Your ref:
Our ref: 21/02408/F
Please ask for: Miss Sandra Homcenko
Direct dial: 01553 616824
Direct fax: 01553 616652
E-mail: borough.planning@west-norfolk.gov.uk

Details: **Garage and Replacement infill Extension at Brieryfield Lady Drove Barroway Drove Downham Market Norfolk**

I have received a planning application as detailed above but cannot process it until I receive some more information:

North West

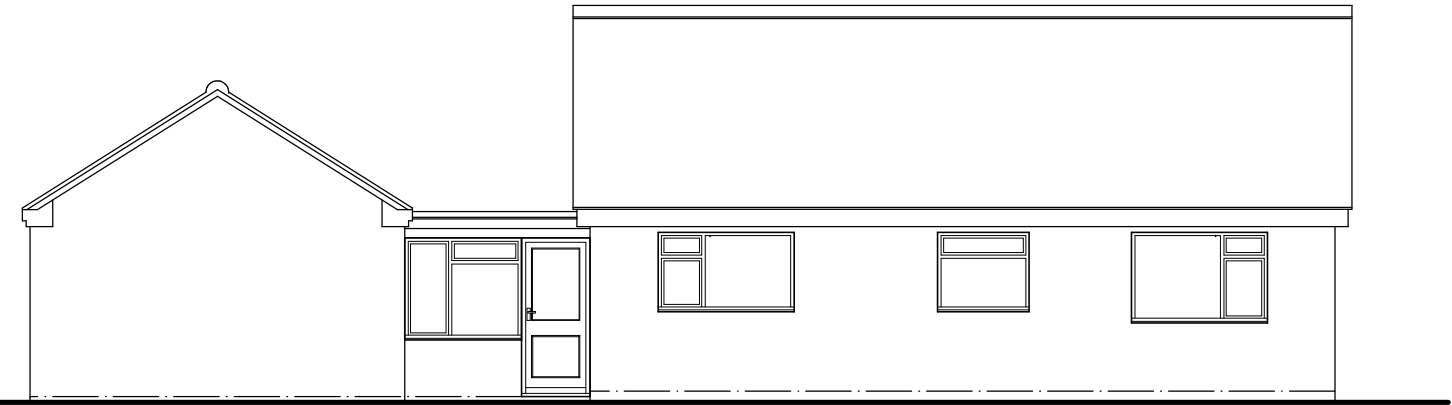
1. Please forward amended Existing plan showing window on NW Elevation
2. As the property lies within an area at risk to flooding, please complete the simplified Matrix and return it. The Matrix can be found at https://www.west-norfolk.gov.uk/info/20173/information_for_planning_agents/231/flood_risk_information
3. Fee payable is £206
